From: [Zach Torrance-Smith](#)
To: jbrunson@fairpoint.net
Cc: [Chris Cruse](#); [Jamey Ayling](#)
Subject: BL-23-00021 Hutchinson
Date: Wednesday, September 13, 2023 3:26:48 PM

We are processing your Boundary Line Adjustment and we are going to need some additional materials added to your site plan in order to be able to deem your application “complete” and move forward with the process of reviewing it with other departments.

HUTCHINSON BLA  
SECS. 2 & 11, T. 18 N., R. 17 E., W.M.  
TPNS 389133, 389133 & 343233

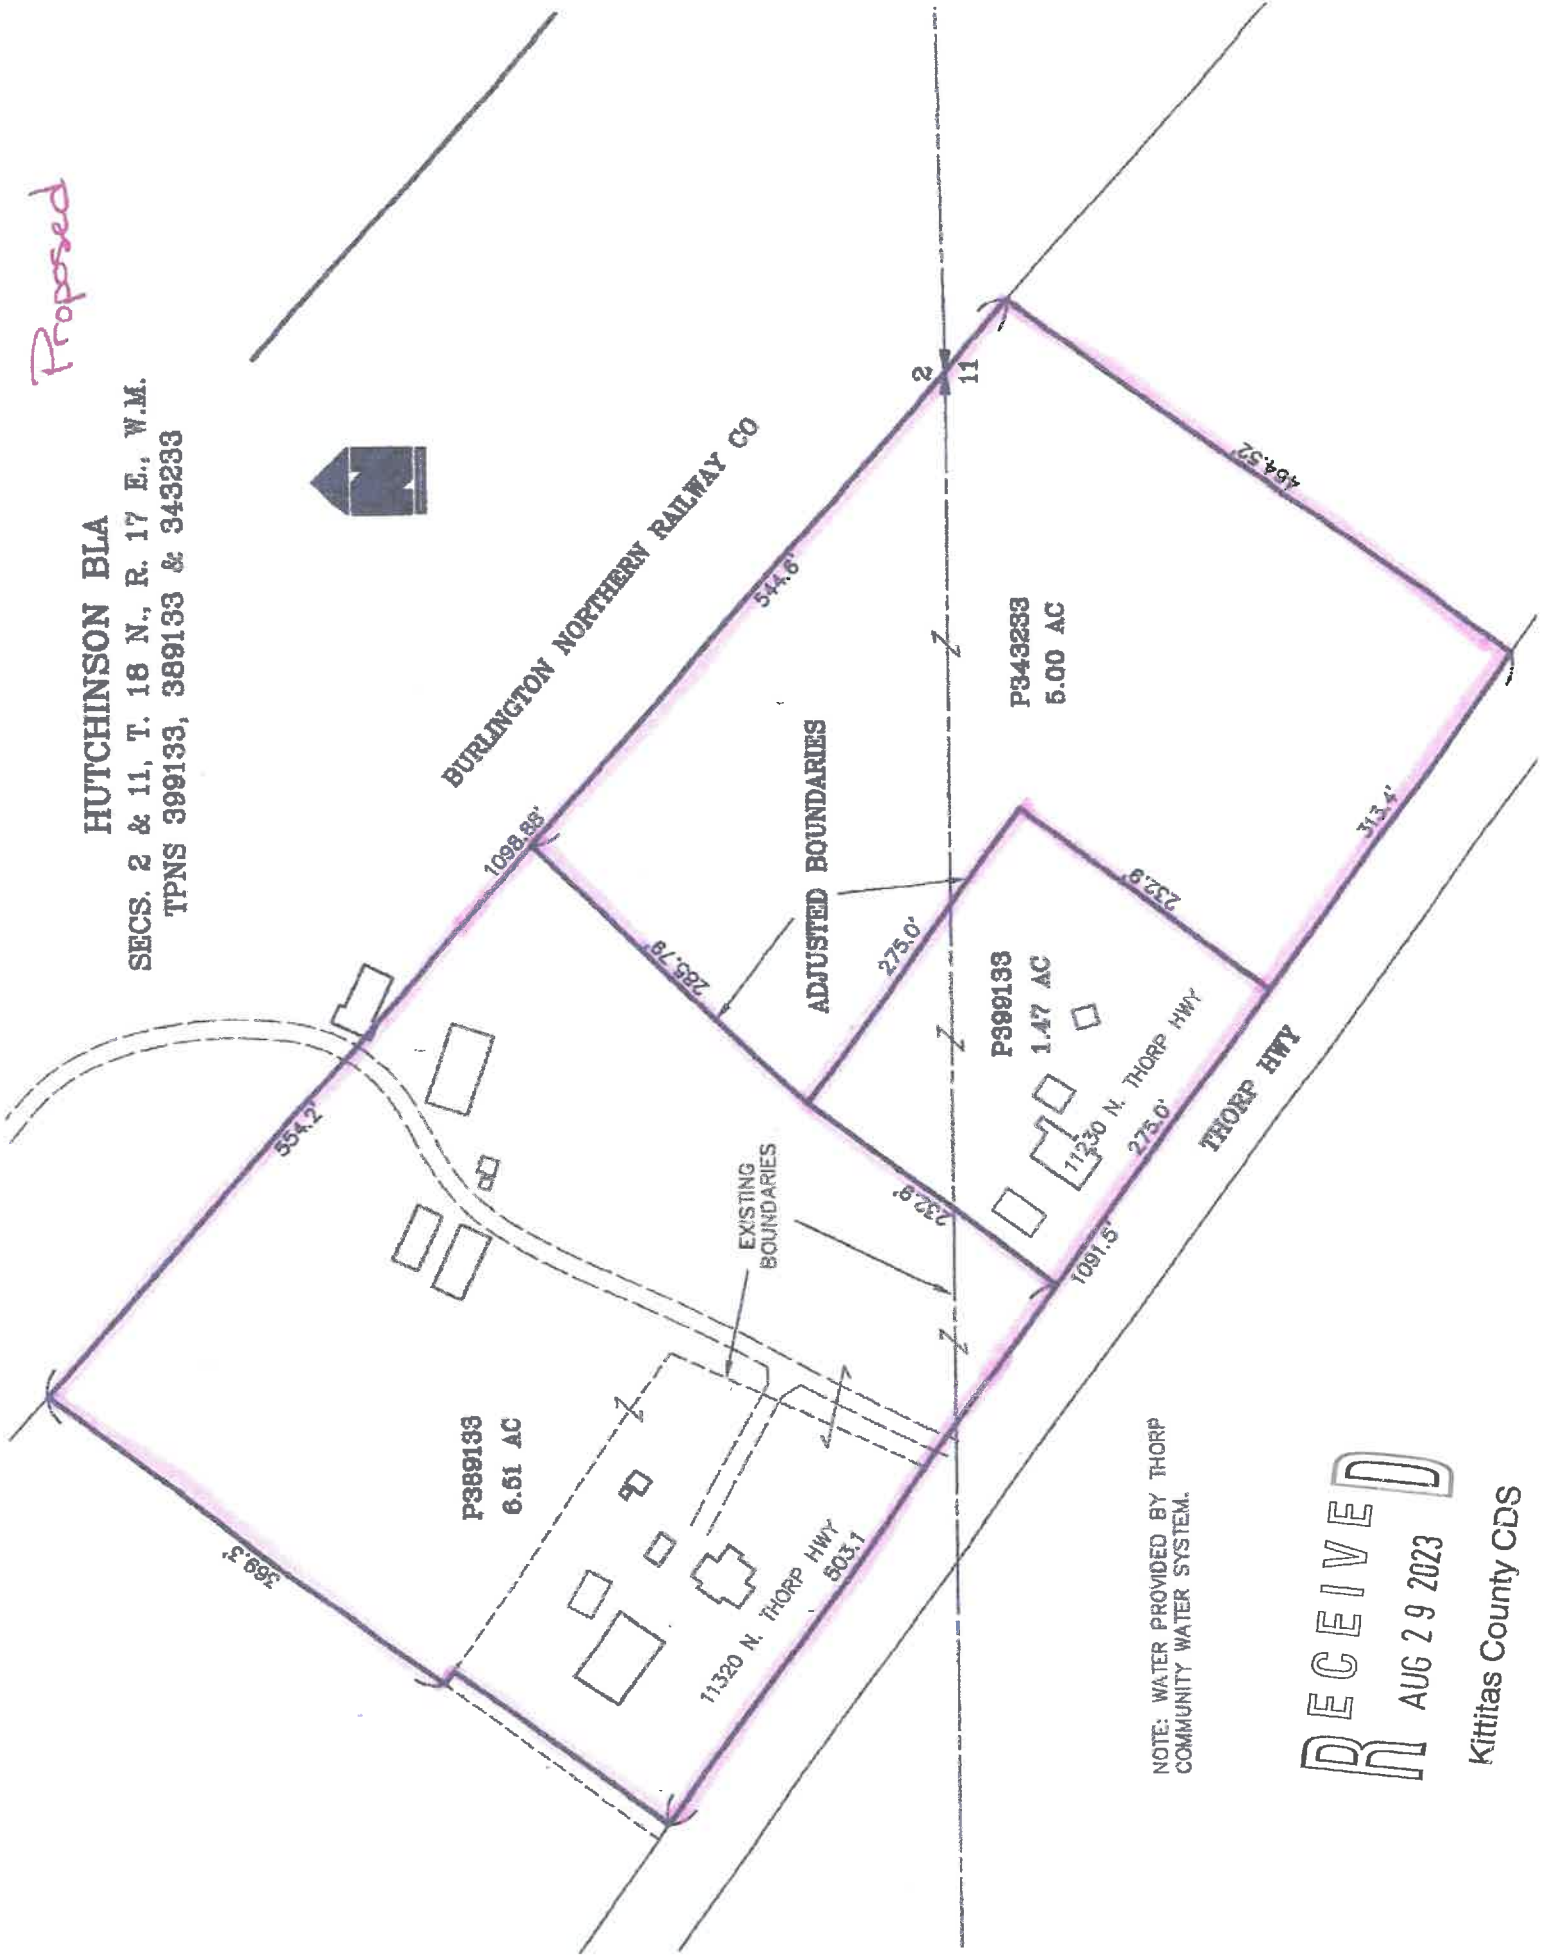
Please add the following elements to your site plan:

- Well heads.
- There is a stream that is showing passing through parcel 389133, that will need to be reflected on the map.
